Application Ref: H08-0846-25

Proposal: **Proposed dwelling**

Location: **Adjacent 3-4 Bowgate, Gosberton, Spalding, PE11 4ND**

ADDITIONAL INFORMATION REQUIRED

Figure 4- Proposed site layout

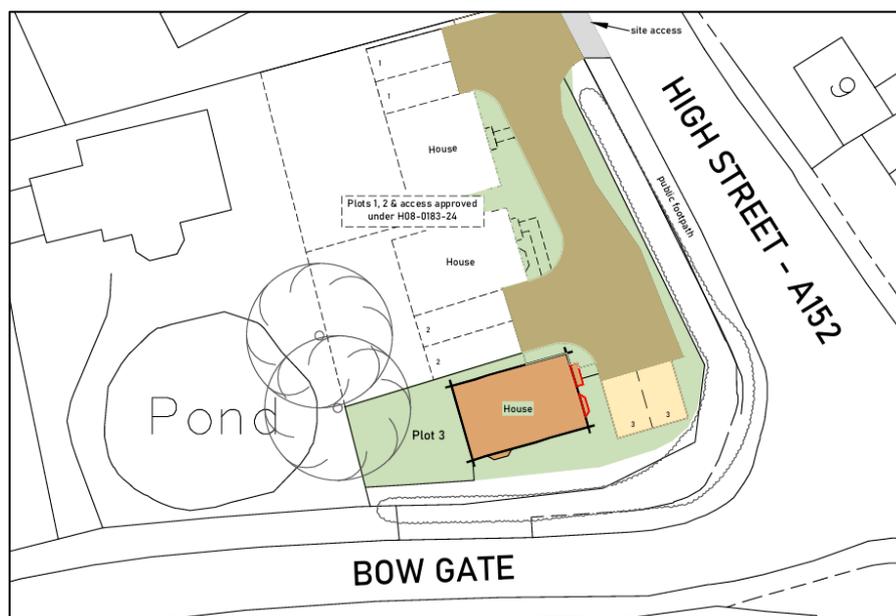
In line with our guidance, we would expect to see three parking spaces for a for a four-bedroom dwelling
